**WEST SUSSEX COUNTY COUNCIL
STRATEGIC PLANNING CONSULTATION**

DATE: 12th August 2014

SUBJECT: LU/150/14/PL - Proposed removal of existing dwelling & erection of a terrace of 3 No. 2 bed houses with parking.

57, Stanley Road, Littlehampton, BN17 6JF

SITE PLAN - 1/500

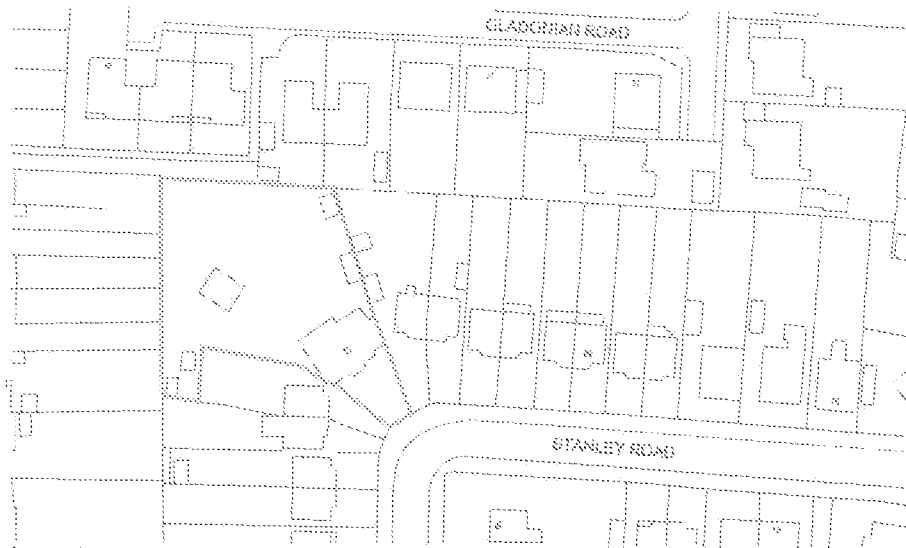
The proposal has highlighted that a fewer than expected number of parking spaces have been provided for this proposal. The applicants will have to demonstrate that the estimated number of vehicles can be accommodated either within the site or via on-street parking.

The application does not include sufficient space for the expected number of vehicles at the development. The applicant should demonstrate that the total number of parking spaces available at the development, either through provision of off-street parking spaces, on-street spaces (on or off the public highway) or a combination of both, is sufficient to accommodate the expected number of vehicles at the development. If some or all vehicles are expected to park on the public highway, then the applicant will need to demonstrate, using a car parking capacity survey, that there is sufficient available space to accommodate the expected number of vehicles. Guidance on the County Council's approach to residential parking and car parking capacity surveys can be found on our website.
